Application by Medworth CHP Limited for an Order Granting Development Consent for the Medworth Energy from Waste Combined Heat and Power Facility

We are writing on behalf of Cambridgeshire County Council and Fenland District Council (the Cambridgeshire Authorities) regarding the Medworth Energy from Waste Combined Heat and Power Facility Development Consent Order (DCO) Examination.

Comments on the Applicant's D2 Submissions

**Figure 10.1i**  
**New Bridge Lane access design**

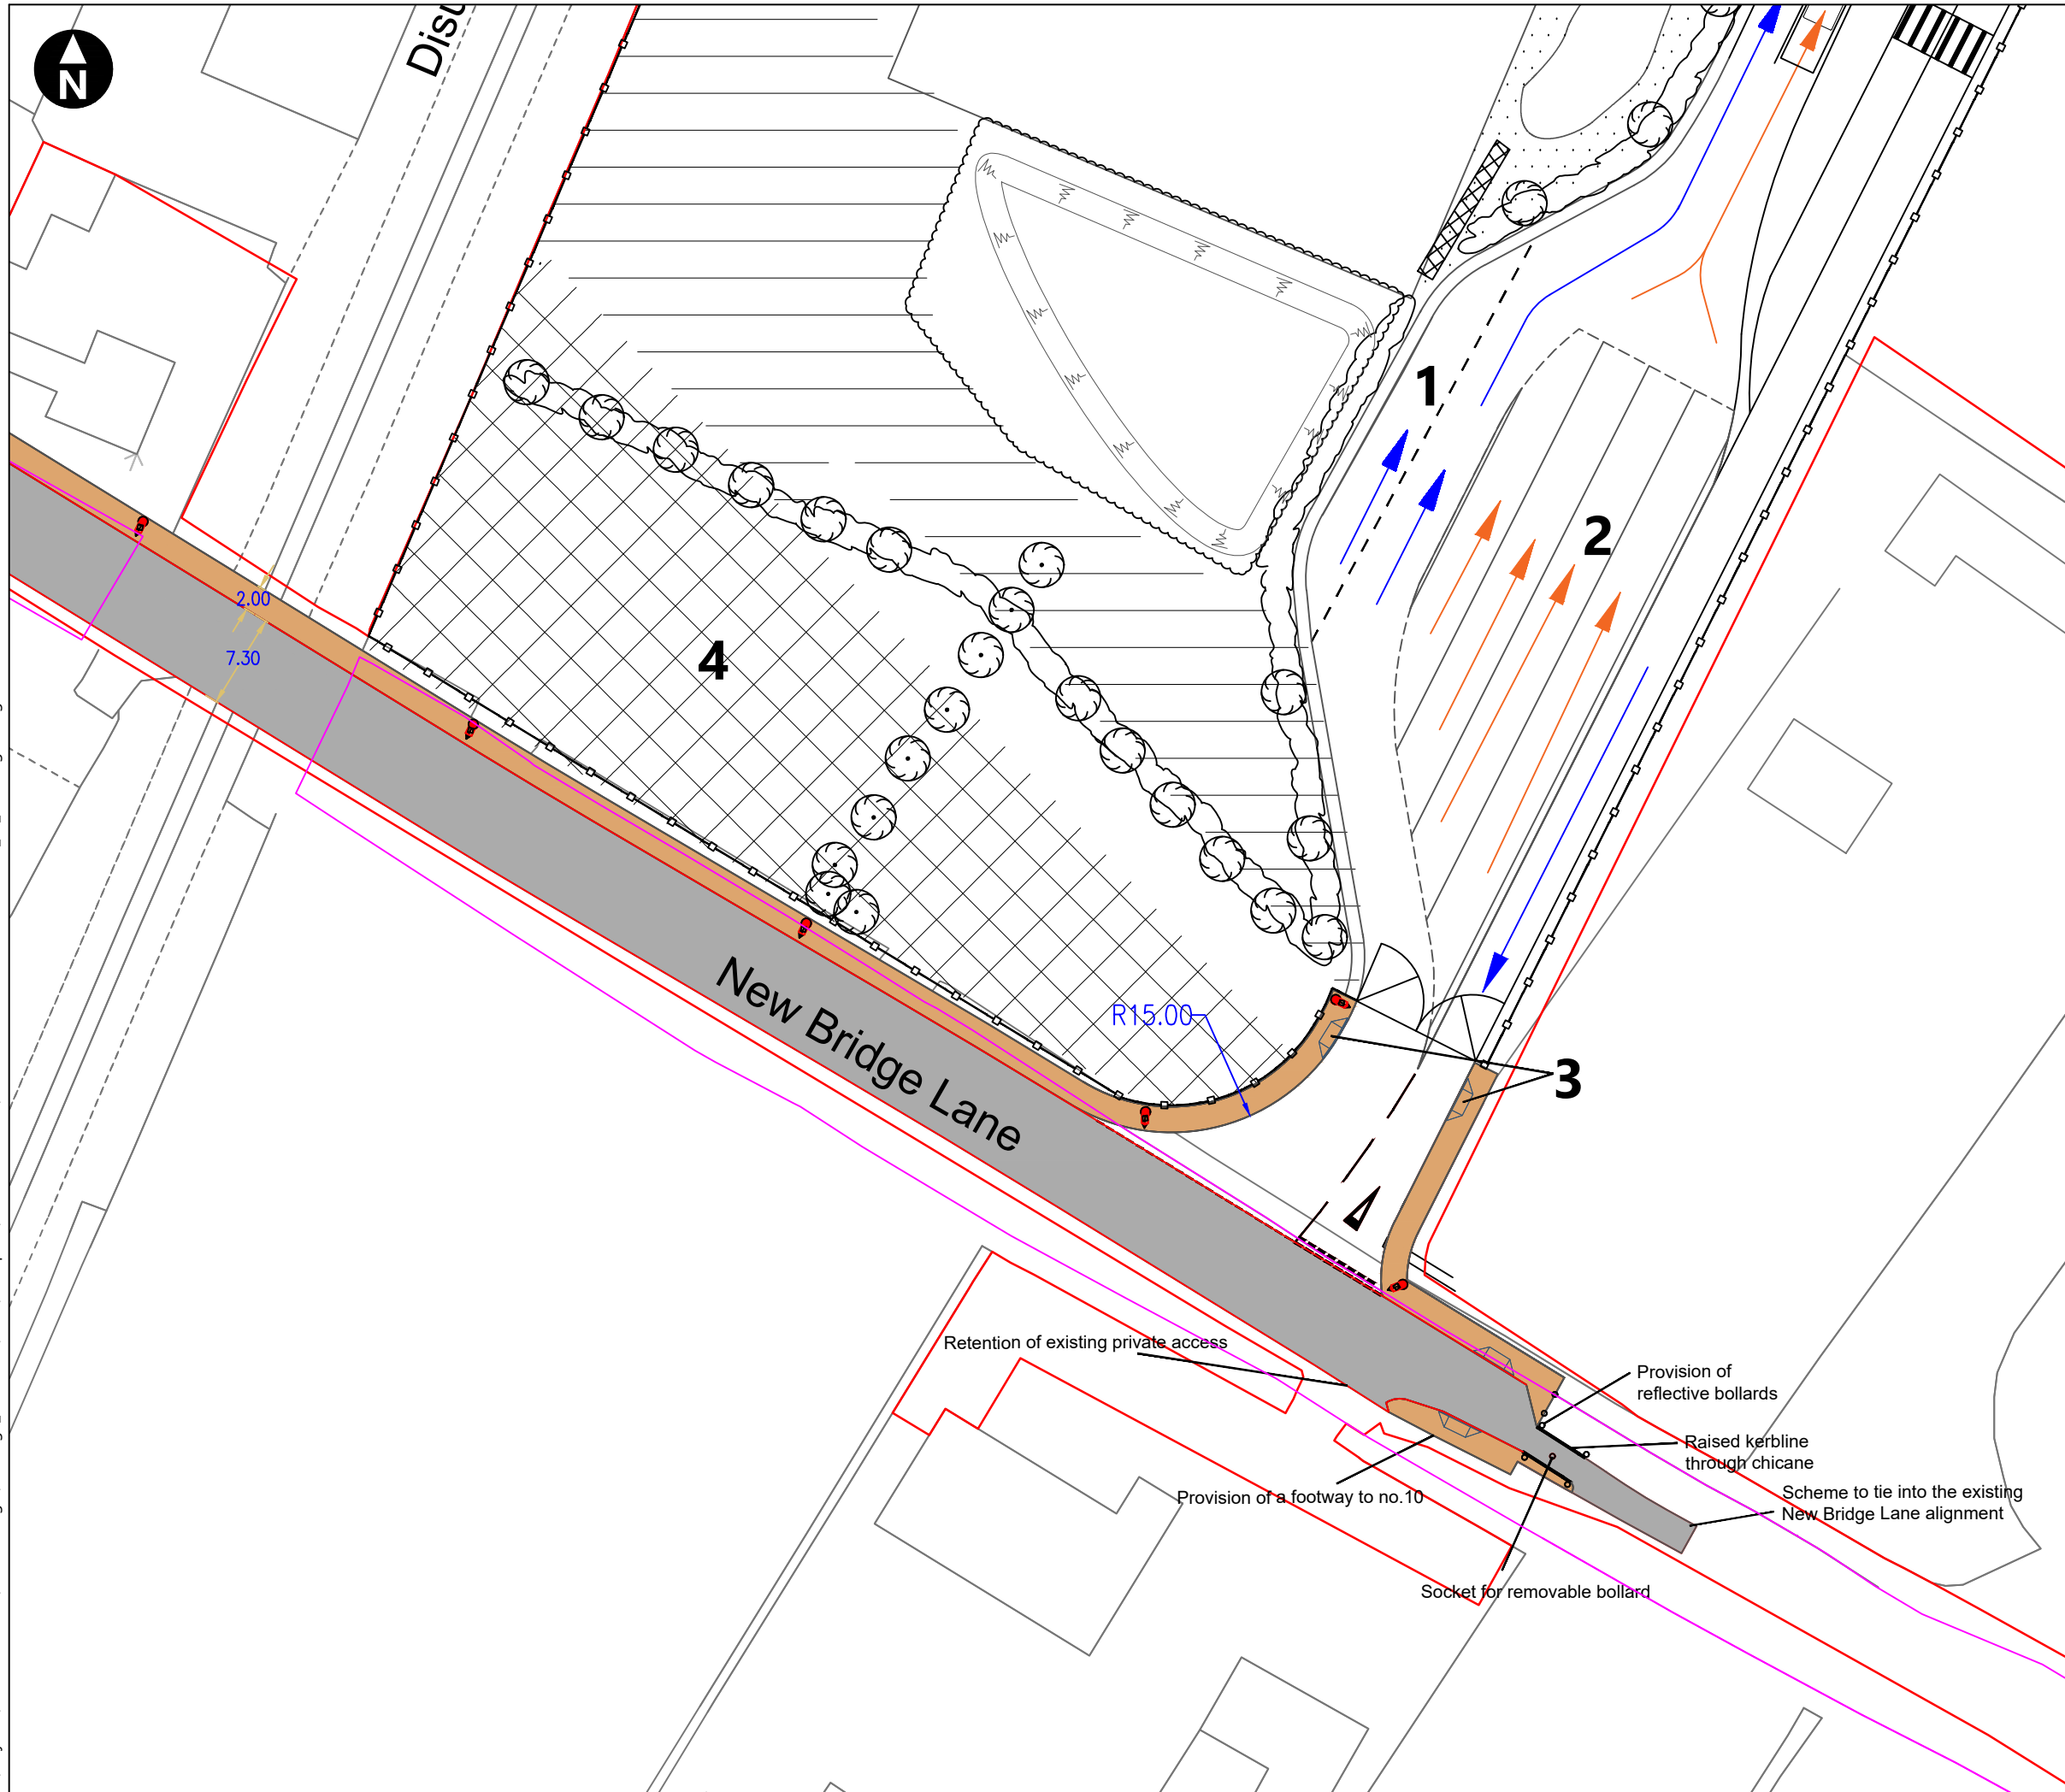
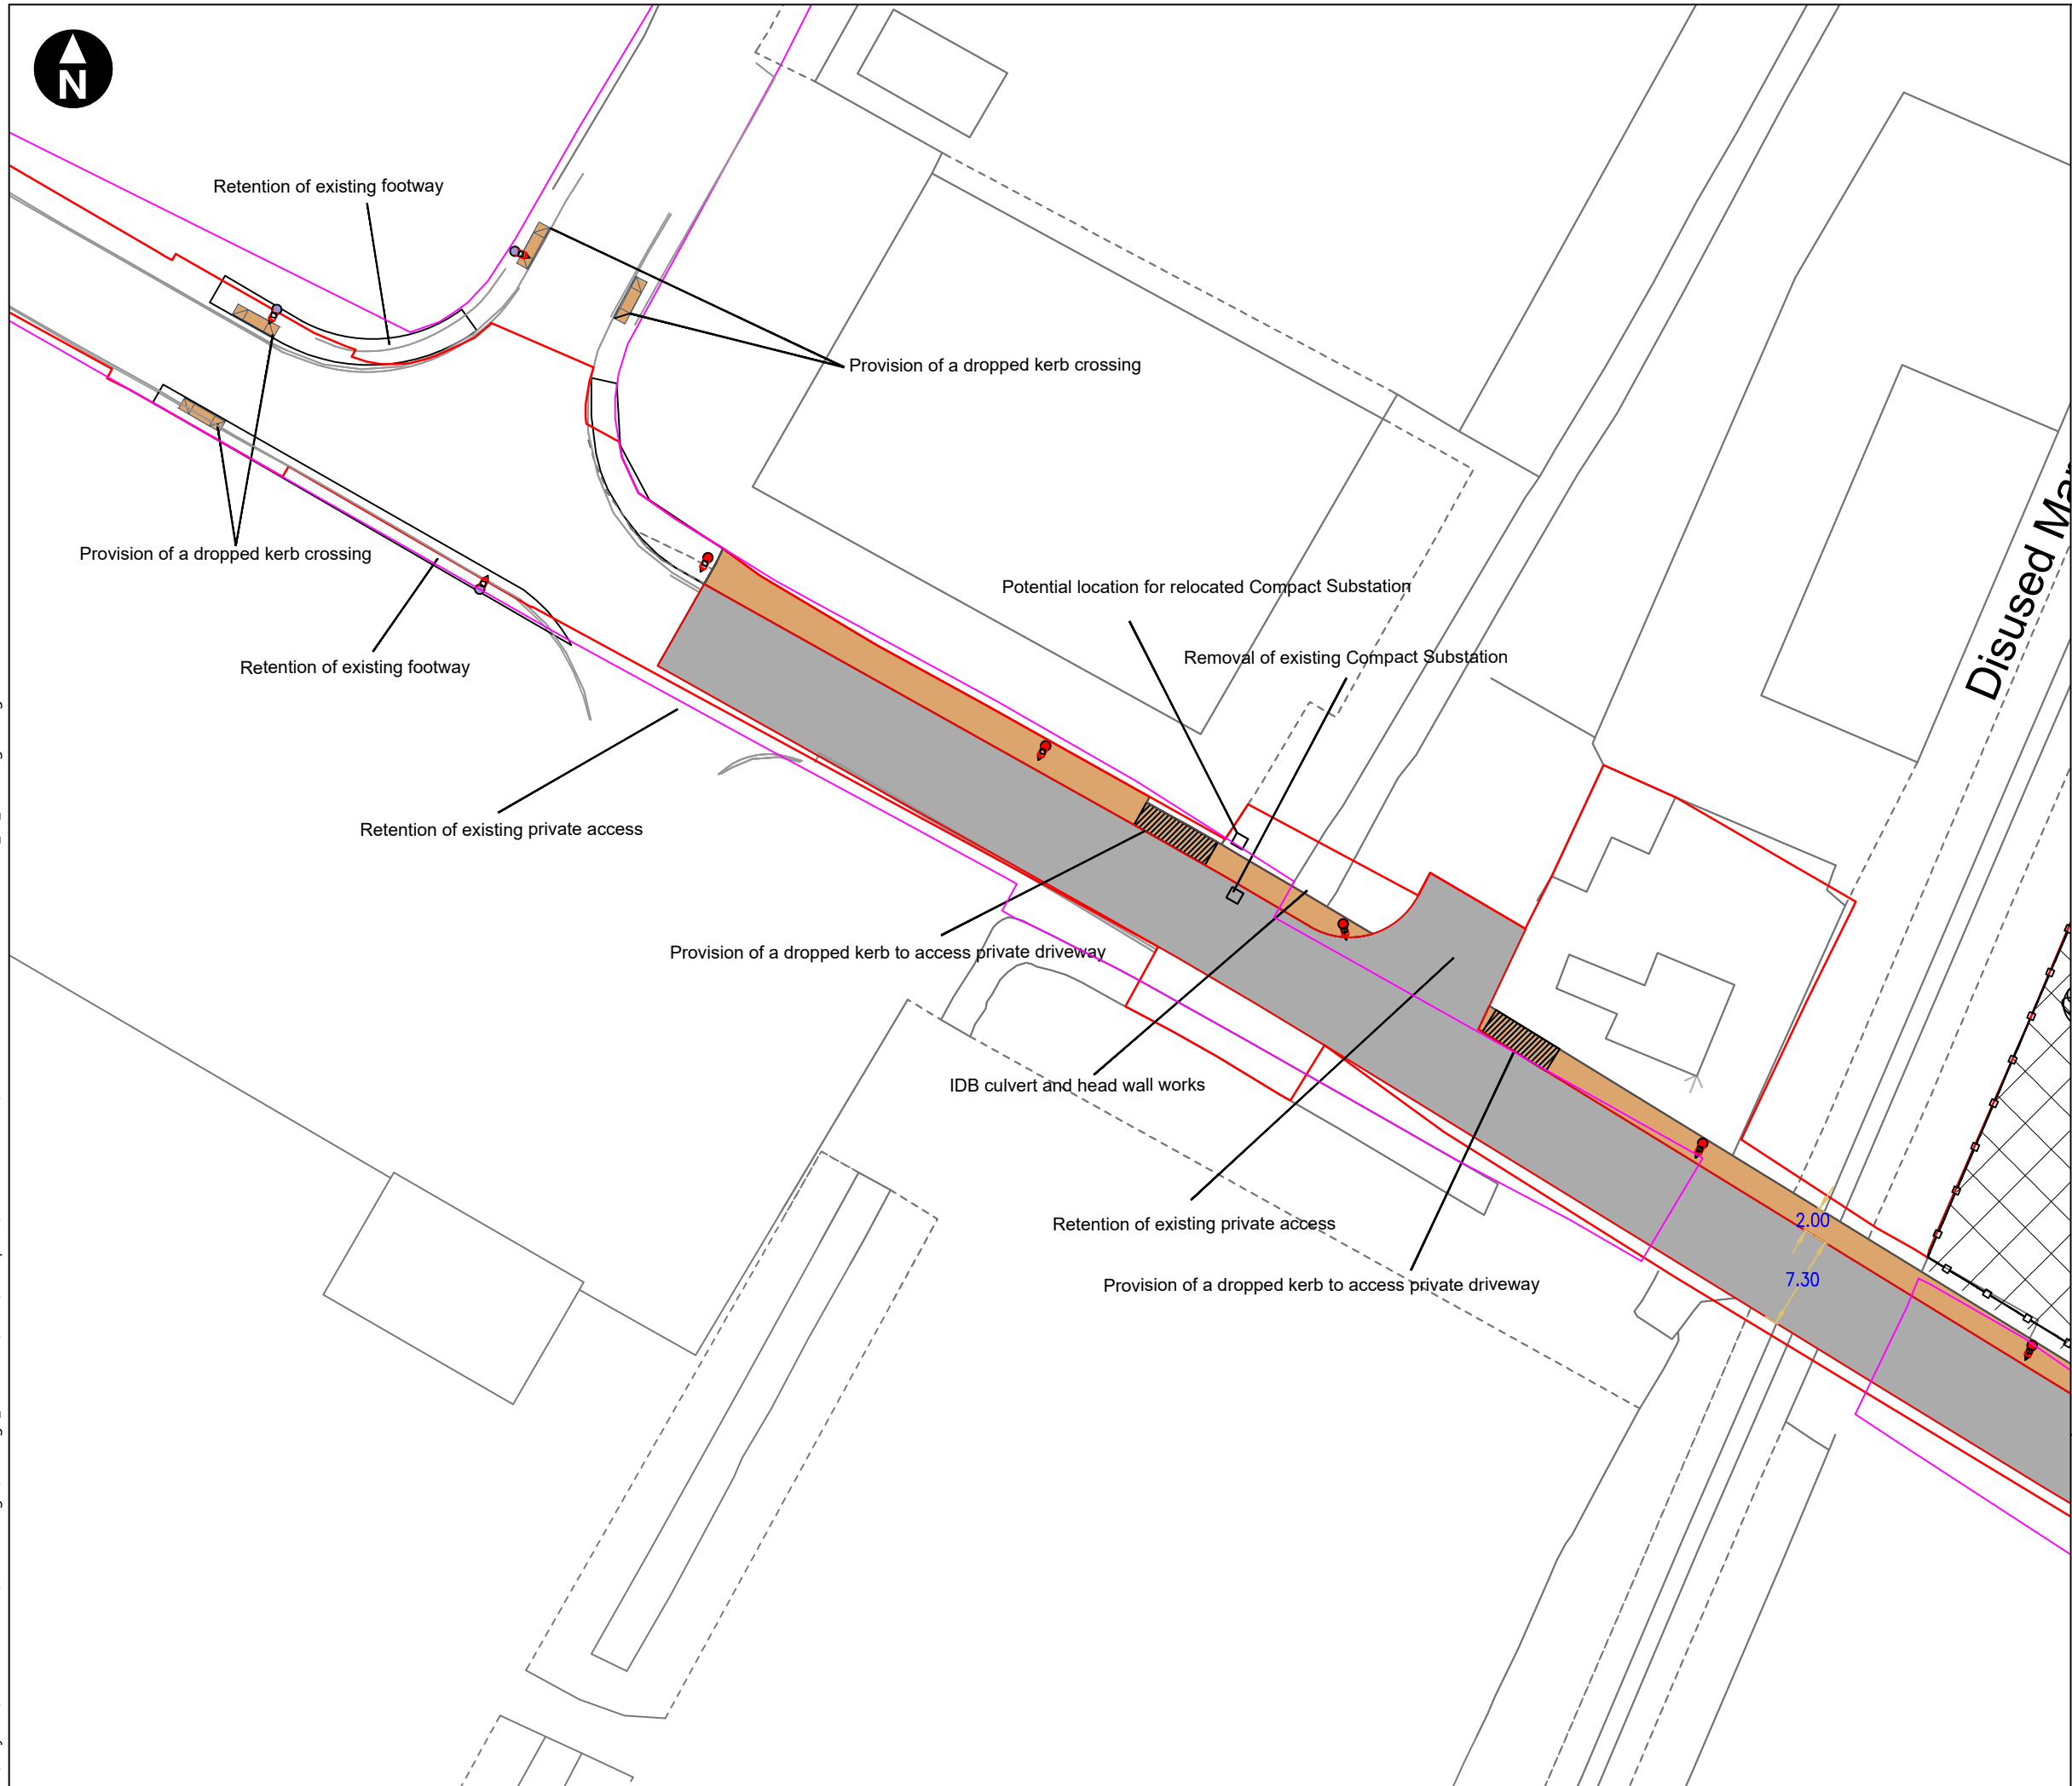
<p>Public rights of way: Construction and Operational Phase Impacts on NMUs and local communities</p>	<p>2.16 and 2.17</p>	<p>CCC has engaged directly with the applicant regarding the impact of its proposed works on the PROWs, Wisbech Byway 21 and Elm Byway 6. These two PROW adjoin the A47 at opposite sides of the carriageway, and therefore in order to continue from one PROW onto the other it is essential to cross the A47. It is noted that the draft DCO boundary does not include any part of these two PROW, however, the proposed linear construction works in the A47 corridor would indirectly affect these two PROW by creating a temporary severance in the ability to cross from one to the other.</p> <p>The works on the A47 are therefore inseparable from the two PROW, and yet no indication of this is present in the draft DCO. CCC welcomes the ongoing engagement with the Applicant regarding this matter and is seeking to agree amendments to the CTMP and OTMP to ensure the impact on these PROW is suitably mitigated. Further work is required in order for the Council to be satisfied that adequate protective provisions are in place.</p> <p>With respect to NMU access along New Bridge Lane, the Council appreciates that this is an unclassified road rather than a PROW, but the context is that Wisbech and the surrounding fenland area have very poor provision of PROW due to their historic nature, and so local roads can provide important connectivity for NMUs where no other facilities exist. This access therefore needs to be seen within the broader policy framework envisaged by NPPF para 100, the Defra 25 year Environment Plan, the ROWIP and the Joint Health & Wellbeing Integrated Care Strategy, working together. As noted in the Council's response to the Applicant's response to ExAQ1 LV 1.3-1.6, the Council welcomes the proposed measures to improve the environment along New Bridge Lane during the operational phase as set out at 2.17.4, p48 of the Applicant's response, but considers that such measures will not be able to completely mitigate the adverse impact of the development on NMUs and the local community.</p> <p>The Outline Operational Traffic Management Plan (OTMP) [REP1-025] does not address the impact that operational traffic will have on NMUs using New Bridge Lane, post-construction. In particular, the section of New Bridge Lane that is to the east of the former level crossing, would, under the Applicant's design (shown in the Figures section of the Outline CTMP [REP1-011]), result in a narrow rural lane that is quietly trafficked becoming a ~7m wide carriageway with a 2m footway alongside it. All green verges in this section appear to be</p>

<p>removed. The physical nature of this part of the road will be transformed and it will be opened to use by HGVs. NMUs will be corralled from a quiet rural road with spacious verges onto a 2m footway running adjacent to an HGV route, with no apparent off-carriageway provision for cycles. Consideration of equestrian users is absent.</p> <p>A signage strategy for NMU traffic is also absent. This is of particular concern in relation to the former level crossing, where it is important that NMUs are not given any impression that the works have diminished their ability to pass and repass. CCC requests that it is consulted on the wording of any signage in this location to ensure that NMUs are not discouraged from using the route. Further to this, rather than relying upon private agreements with Network Rail, it would be preferable if a public permissive agreement for access across the level crossing were reached. This would provide reassurance to the Council and to public users that the ability to use the route has not been diminished. The Council requires involvement in the making of such an agreement. The Council refers to its additional comments regarding the access over the level crossing at 2.4.6 above.</p> <p>Further, the Council notes that there will also be wider visual landscape impacts affecting recreational users of a number of existing PROW and local roads broadly south and west of the development. Therefore, the Council seeks additional mitigation, as set out in its response to the Applicant's response to the ExAQ1 LV 1.3-1.6. There is scope for such mitigation to help meet the problem of insufficient BNG provision through a solution that involves the provision of appropriate habitat which includes public access provision within the vicinity of the development and local community affected. The Outline Landscape and Ecology Management Plan [APP-098] should be amended to reflect the adverse impact on recreational use of PROWs and local communities within the wider landscape, and should propose appropriate mitigation. The Council would welcome engagement with the Applicant to discuss this further.</p>
